# Engineers Comments Regarding Surface Water Drainage

<b>Application Reference:</b>	M/22/25/PL	<b>Reviewer Reference:</b>	ADC/PC
<b>Planning Officer:</b>	Harry Chalk	<b>Date of Review:</b>	10/06/2025
<b>Site Name:</b>	86 Ancton Way Middleton-on-sea PO22 6JP		
<b>Application Description:</b>	Demolition and erection of 1 No dwelling. This application is in CIL Zone 4 and is CIL Liable as a new dwelling.		
<b>Assessment Number:</b>	1 of 1

DRAINAGE BLANKET BENEATH PATIO

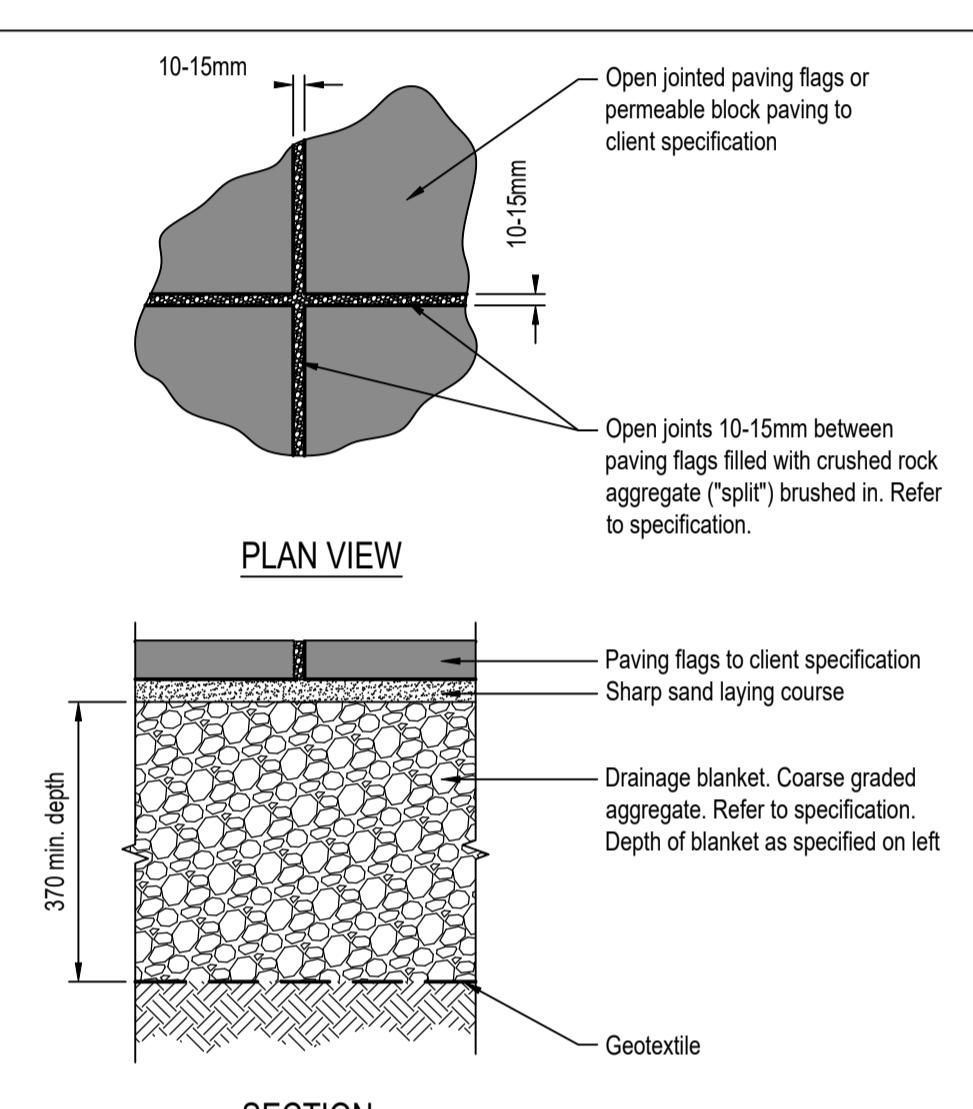
construction details for the proposed drainage blanket beneath the patio also does not replicate the proposed aggregate construction depths indicated on the layout plan view. Clarity should be provided by providing peak groundwater levels and formation levels for infiltration devices, to a common datum. AOD would be the preference. The construction details should be adjusted as necessary.

PROPOSED SURFACE WATER DRAINAGE

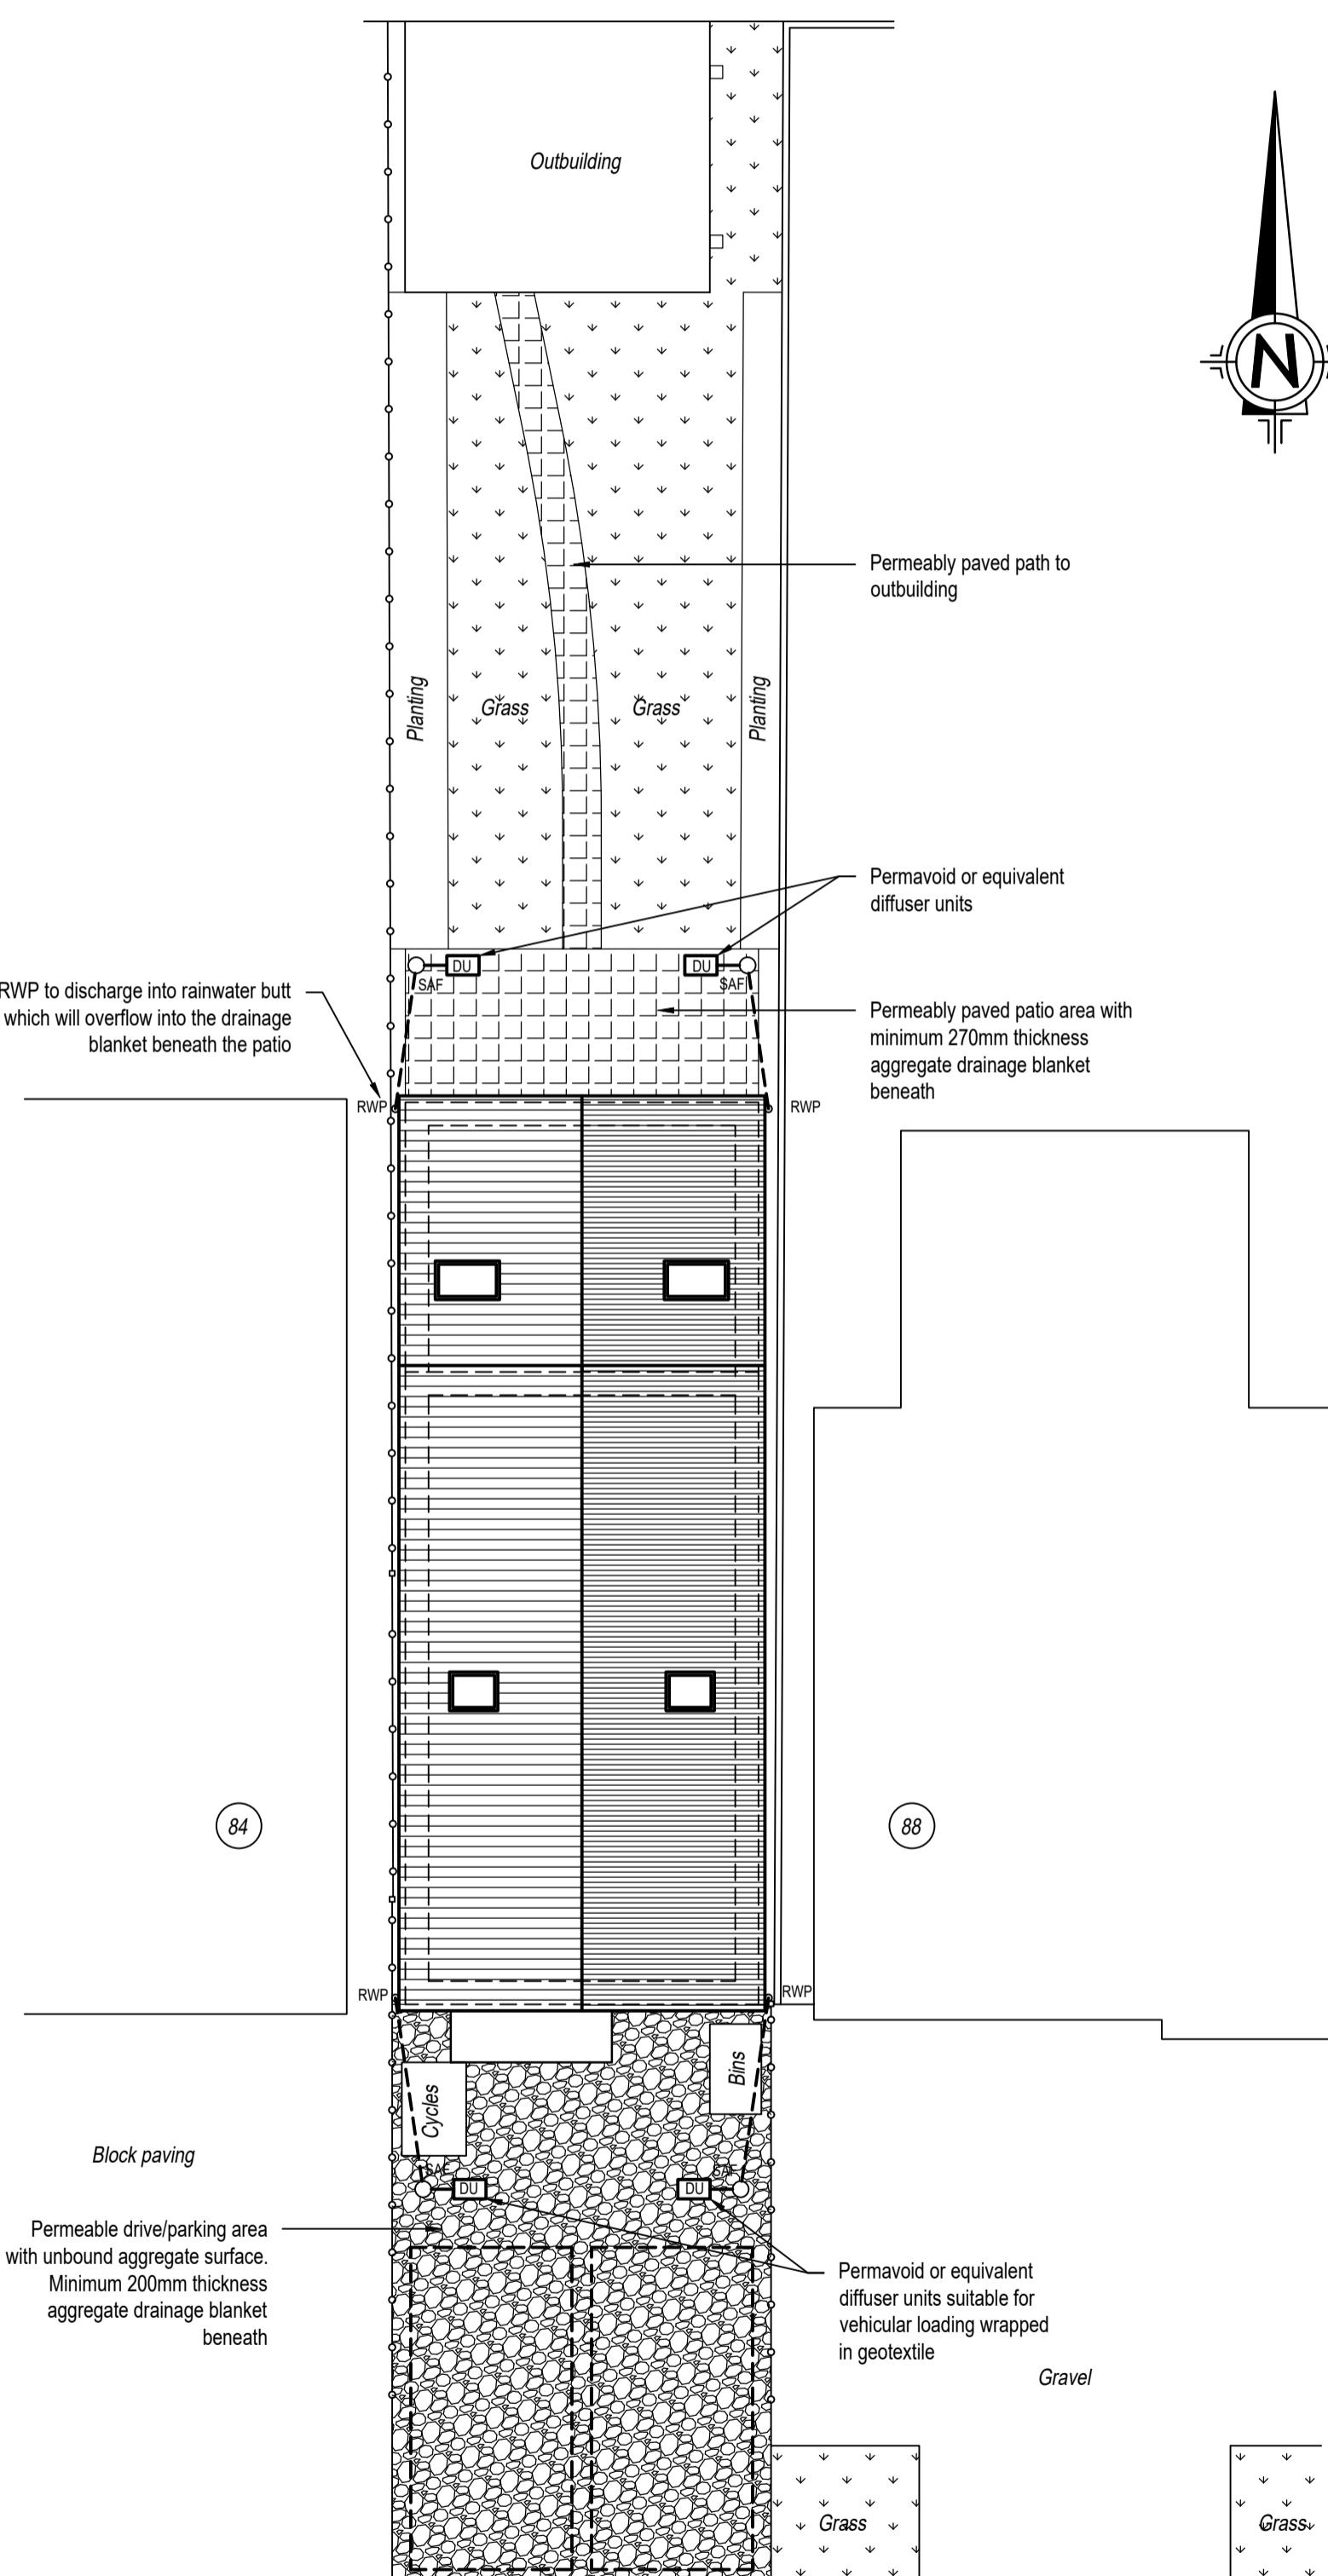
An infiltration design has been proposed. Groundwater levels have been monitored which revealed a peak groundwater level of 1.23m below ground level on the 30<sup>th</sup> January 2025. The design has tried to ensure that 1m of unsaturated ground is provided between the base of the infiltration structures and the peak groundwater level. However, it is unclear as to whether 1m is truly being achieved based upon the construction depths, particularly for the rear infiltration structure. The

A plan showing the location of the groundwater monitoring point should also be provided.

In order to achieve such a design, a very shallow drainage system is being proposed, which has its challenges in terms of pipework configuration, etc. The layout plan should indicate all pipe invert levels, diameters, diffuser unit invert levels, manhole cover/invert levels, infiltration blanket formation levels, permeable paving/patio finished surface levels and infiltration structure plan areas/dimensions. Diffuser units should be 5m distance from buildings and this needs to be clearly indicated on the plans.

The calculations provided are from software that it is unfamiliar to us and we would require further information in this respect. Surface water run off from the patio area is not included in the calculations so it is assumed that it will drain onto garden/grass areas – clarification required. Surface water runoff from the driveway appears not to be accounted for? Urban creep at 10% of the roof area also needs to be included. FEH rainfall data is to be used, however, the calculations are unclear in this respect. Infiltration for calculation purposes is to be through the base only – it is unclear if the sides have been utilised too? The calculations should be supported by an impermeable area plan, clearly indicating the drained areas and corresponding areas (m<sup>2</sup>).
